Tamworth Hospital Redevelopment SSD - 5204 Submissions Report

16 October 2012

This Report has been prepared by AECOM Australia on behalf of the Proponent, NSW Health Infrastructure. The Report provides a response to the submissions received during the public exhibition of State Significant Development Application 5204 for the proposed Tamworth Hospital Redevelopment, located at 31 Dean Street Tamworth NSW. To confirm, development approval is sought for:

Figure 33 – Dean Street access points

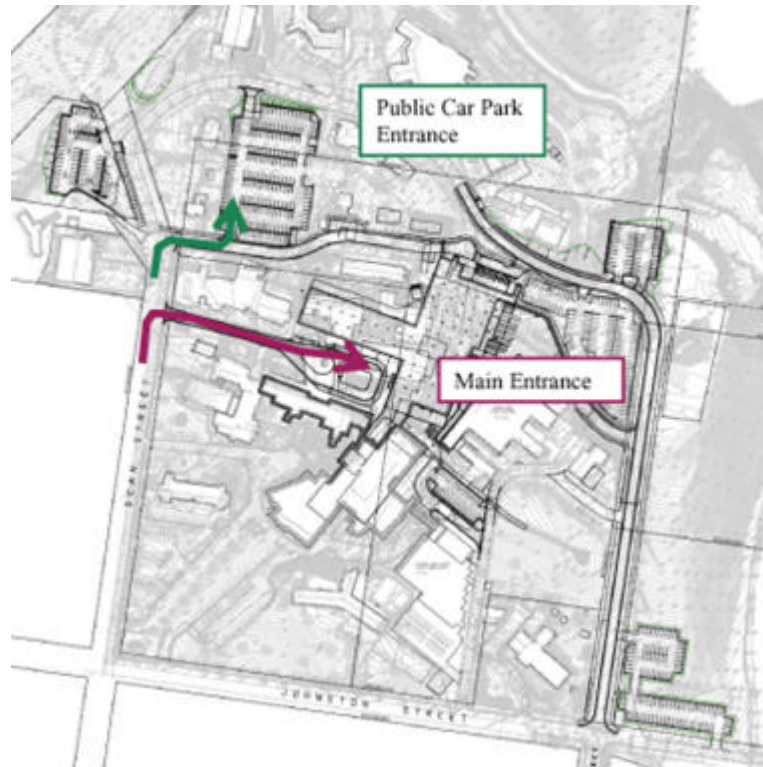
Access points around Dean Street and Johnston Street should be rationalised.	The use of the southern driveways on Dean Street will reduce once the public car parking is moved into the central car park. Redundant driveways will be removed.
The north-west access point to the Koolkuna Building (directly opposite the main access) could be closed and relocated to form a western stub of the proposed new	This car park provides 11 spaces for staff and 12 spaces for visitors. With this low number of spaces, car turnover is low. There is no proposal to change the

RMS Comment	Response
roundabout.	existing site access driveway. Relocating it as part of the roundabout would add a fifth leg, which would be confusing for drivers.
Ambulance access may be more direct via the private vehicle, with a boom gate at the internal cul-de-sac end rather than the internal ring road.	<p>The site access principle is for the public to enter from Dean Street, and hospital vehicles (including the ambulance) to enter from Smith Street. There is still flexibility for ambulances to travel around the proposed internal ring road in both directions, and this will be necessary when the eastern area of the ring road is closed during operation of the helipad.</p> <p>It is noted that access has been developed in consultation with the NSW Ambulance Service.</p>
Buses and Service vehicles should be able to enter and leave in a forward direction.	All bus and service bay areas will be designed for entry and exit in a forward direction.

Figure 41 – Car parking being delivered as part of this SSD application

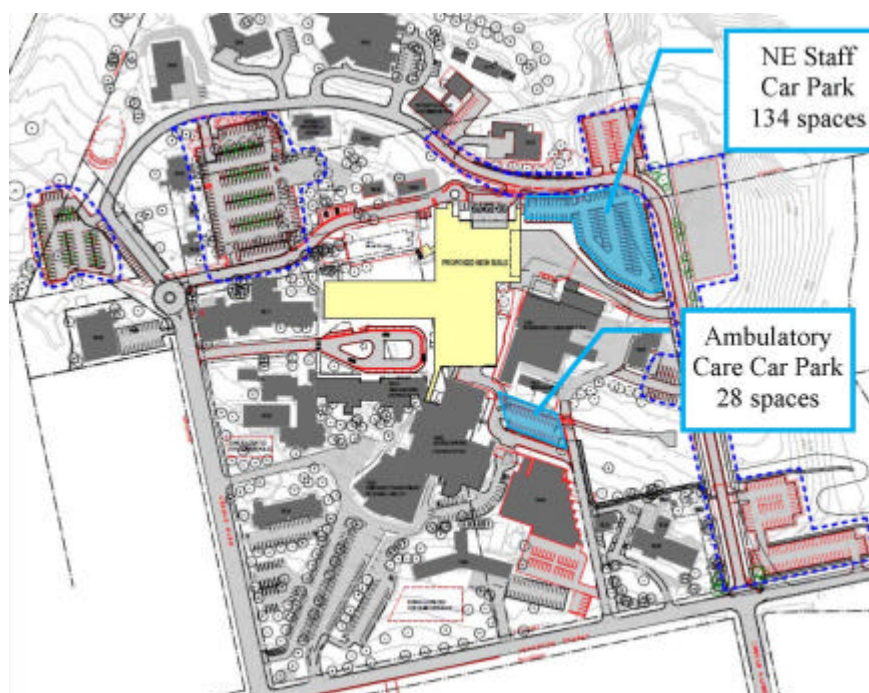
<p>Transport and Accessibility Concern of Council that on-site parking will be consumed mainly by staff and that public transport travel to and from the site will not increase.</p>	The central car park will provide 191 spaces and be designated for public use by visitors and patients. It will be time restricted and enforced under the hospitals declared status. Additional patient parking is located in a number of locations around the site adjacent to the specialist units.
Early staff may park close to the main entrance, with visitors left to park in outer parking areas through the remainder of the day. Staff should park in the outer parking areas.	Designated areas will be provided for visitor, patients, and staff.
A Parking Management Plan should be developed to allocate areas dedicated only for visitors and also pay parking system across the entire campus.	<p>A Parking Management plan will be prepared by the hospital. The central car park will include a pay parking system with time restriction similar to that currently in place in the southern visitor car park. The mitigation measures have been revised to develop this.</p> <p>All staff car parks are designed to be able to accommodate the installation of access control</p>

Tamworth Council Comment	Response
	measures (boom gates), should this be required in the future.
Clarification of the provision of the northwest informal parking area is required. This is included in the provision of 1081 spaces on the site however is noted as future expansion in the ARUP report. The delivery of this carpark should be a condition of approval of the DA.	The northwest informal car park currently has 33 spaces which have been counted as part of the total provision. Future expansion of this area has not been included, however could deliver a further 40 spaces if the land becomes available. This expansion has not been relied upon and does not form part of the SSD.
Council supports discussions by the proponent to redirect bus access into the hospital, compared to current requirement of working their way around the campus.	The bus route already traverses the hospital and would be relocated onto the new section of the proposed ring road. Bus stops will be provided for bus passengers. Discussions have been held with Tamworth Buslines regarding reversal of the bus route around the site. This would allow bus stops to be located on the inside of the ring road and would require construction of a bus stop on Johnston Street, opposite the Tamwell Centre.

Figure 42 – Stormwater catchments

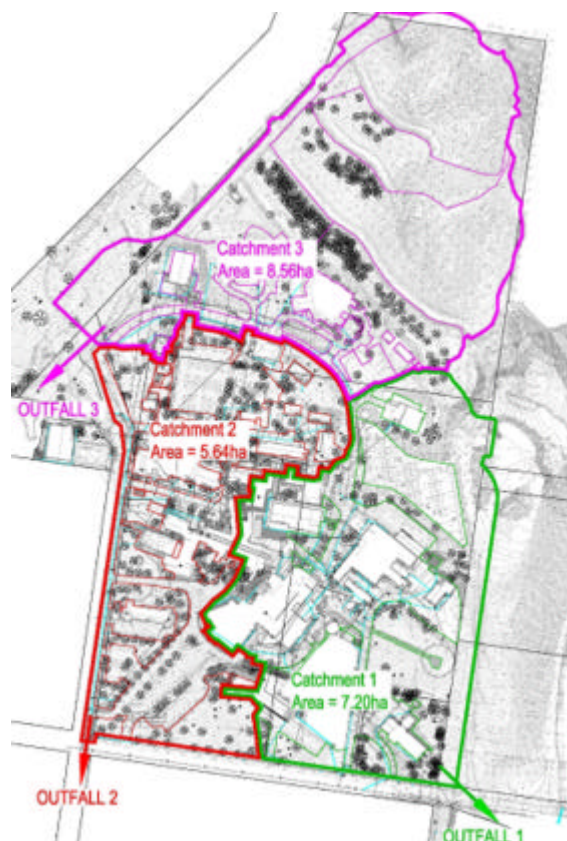
Tamworth Council Comment	Response
Council provides no objection to the proposal, subject to the following comments being addressed:	
<p>Stormwater</p> <p>The Creek west of the site has no capacity. Drainage infrastructure in Dean Street and Johnston Street can accommodate only minor flows from the development. On site detention should be supplied to control the discharge to 0.6m³/s for events up to and including the 1 in 10 year ARI event. Recommended conditions of consent are provided for stormwater below:</p>	<p>A Plan for Catchment 2 is attached at Appendix A.</p> <p>The current runoff rate in the 10 year event is 1.531m³/s. The request for improvements over the existing condition is not warranted as Catchment 2 is not significantly impacted by the proposal.</p>
<p><i>Recommended condition of consent: catchment 1:</i></p> <p>All stormwater flows off roof areas within catchment 1 shall be plumbed and piped in accordance with AS3500 to the concrete channel on the southern side of Johnston Street between Smith Street and Bligh Street. All stormwater flows of hardstand areas for peak flow events up to and including the 1 in 10 year ARI event shall be piped to the concrete channel on the</p>	<p>Agreed and reflected by the current proposal.</p> <p>Mitigation measures revised to confirm acceptance of this condition of consent.</p>

Tamworth Council Comment	Response
southern side of Johnston Street between Smith Street and Bligh Street.	
<p><i>Recommended condition of consent: catchment 2:</i> All stormwater flows off roof areas within catchment 2 shall be plumbed and piped in accordance with AS3500 to Councils existing stormwater infrastructure at the north eastern corner of the Dean Street and Johnston Street intersection.</p> <p>All stormwater flows to hardstand areas for peak flow event up to and including the 1 in 10 year ARI event shall be piped to Councils existing stormwater infrastructure at the north-eastern corner of the Dean and Johnston Street intersection. Onsite detention systems shall be provided such that the discharge for the peak flow in the 1 in 10 year ARI event does not exceed 0.6m/3.</p>	<p>This condition is not agreed to.</p> <p>An updated Catchment Plan is provided at Appendix A. Catchment 2a and 2b have been reduced with parts of these catchments redirected to the south east corner. Catchment 2c has also been reduced marginally. These amendments will result in a significant improvement to the current run off condition. It is noted that these amendments have been discussed with Council.</p> <p>The detention storage required to reduce catchment 2 runoff to 0.6cu.m/s is 470cu.m would require additional pipe work on the western site boundary parallel to that in Dean St, which is unnecessary based on the above.</p>

<p><i>Recommended condition of consent: catchment 3:</i></p> <p>Onsite stormwater detention systems to control developed flows to natural flows across the range 1 in 1 year ARI to 1 in 100 year ARI events for all roof and hardstand areas shall be provided.</p>	<p>This condition is not agreed to.</p> <p>Detention for catchment 3 has been designed to limit proposed run off beyond the existing condition.</p> <p>To reduce flows from catchment 3 to natural (predevelopment) flows from the 2 year to 100 year ARI events, 1100cu.m storage would be required which is considered unnecessary based on the above.</p>
<p>Water The alterations to water servicing connections proposed by the development application are acceptable to Council.</p>	Noted.
<p>Sewer The connection of sanitary plumbing and drainage from the Acute Services Building to the 150mm Council sewer main located in Smith Street is reliant on confirmation that there is capacity of this main.</p>	Council have since confirmed, following further modelling, that the main located (which is actually located in Johnston Street) has capacity to accommodate the flow from the proposed Acute Services Building.
